Our ref: RA/2023/145899/08-L01
Your ref: 2023/91441

Date: 22 September 2025

(AMENDED INFORMATION SUBMITTED) CHANGE OF USE AND ALTERATIONS TO FORMER CHURCH (B8-STORAGE) TO 9 RESIDENTIAL UNITS (C3) AND FORMATION OF CAR PARK (LISTED BUILDING WITHIN A CONSERVATION AREA)

AT 31 CHAPEL HILL, LINTHWAITE, HUDDERSFIELD, HD7 5NJ

Drawing:  
 Proposed  
 Site Sections

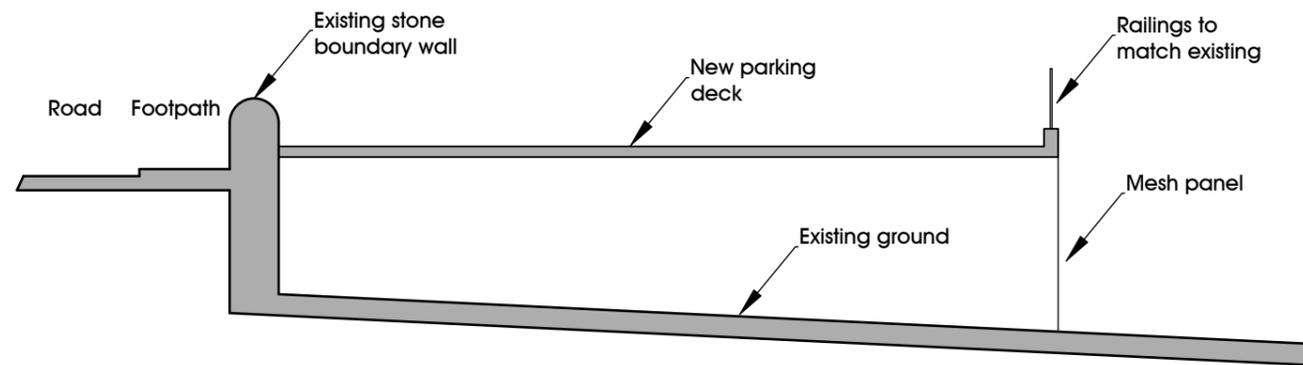
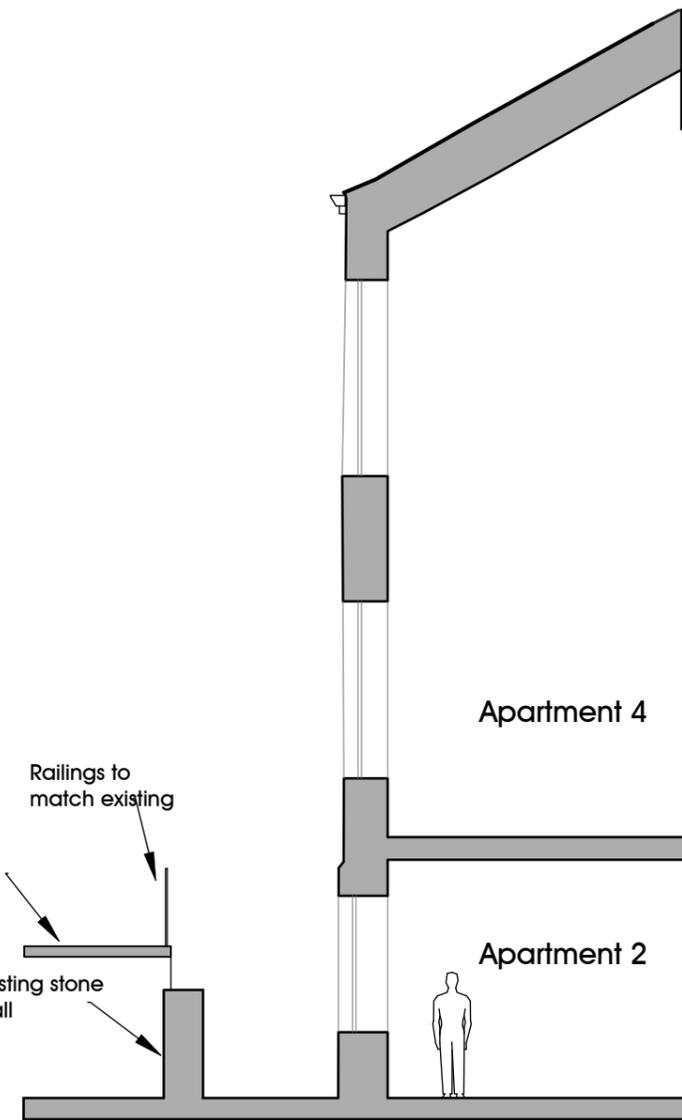
It still does not appear that the site section drawings and plan view layout correspond in representation of size and scale of the proposal. The cross section and plan drawings already provided should be amended to be to scale. The lines on the plan drawing should represent the distances and full extent of the cross sections provided. It would also provide us with a more accurate understanding if the drawings could be labelled with distances to show that the cross sections clearly correspond to the development plans.

Drawing:
Proposed
Site Sections

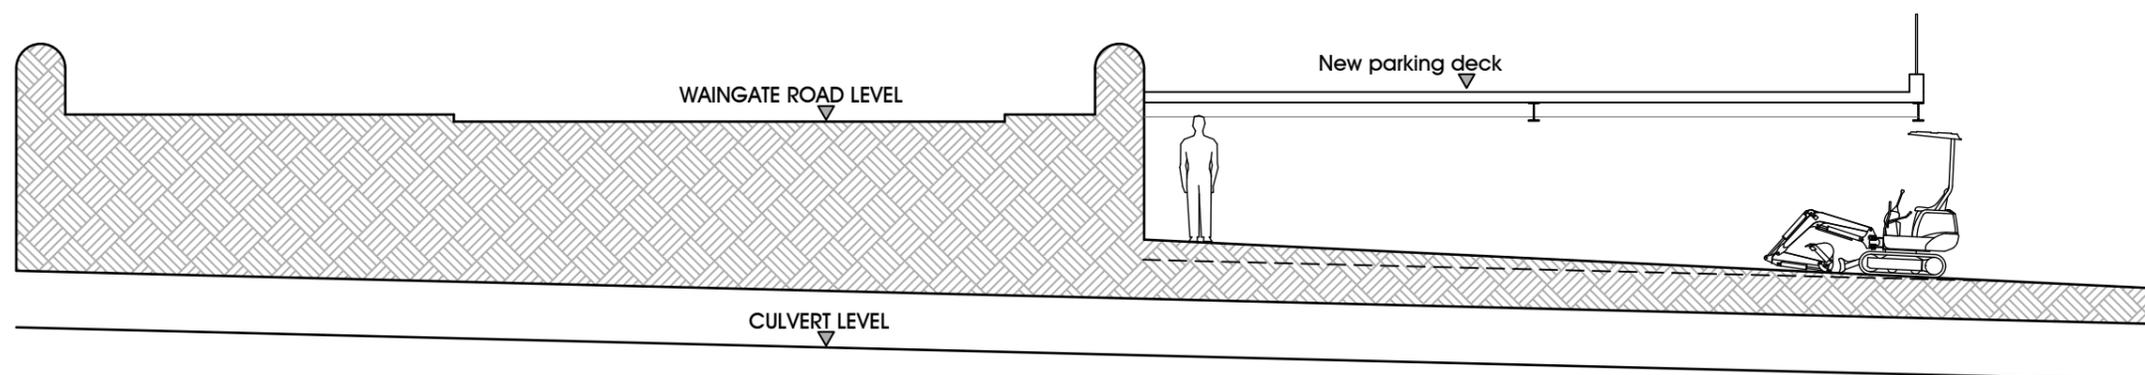
The drawing submitted doesn't address our previous concerns relating to access to the culvert for maintenance. The applicant must demonstrate that unrestricted access to the culvert will be maintained despite the proposals. This is recommended to ensure any required maintenance works to the structure can be carried out. As things stand with the current proposal, although the information shows an intended access route, the deck will still present a restriction to the current level of access. It is important that the applicant demonstrates that the access available, post development, is adequate for any required maintenance.

The applicant may choose to demonstrate how a worst-case maintenance scenario could still be achieved post development. This may explain how any required equipment/ machinery could operate with the proposed development in place. The applicant could also provide any other form of evidence they consider appropriate.
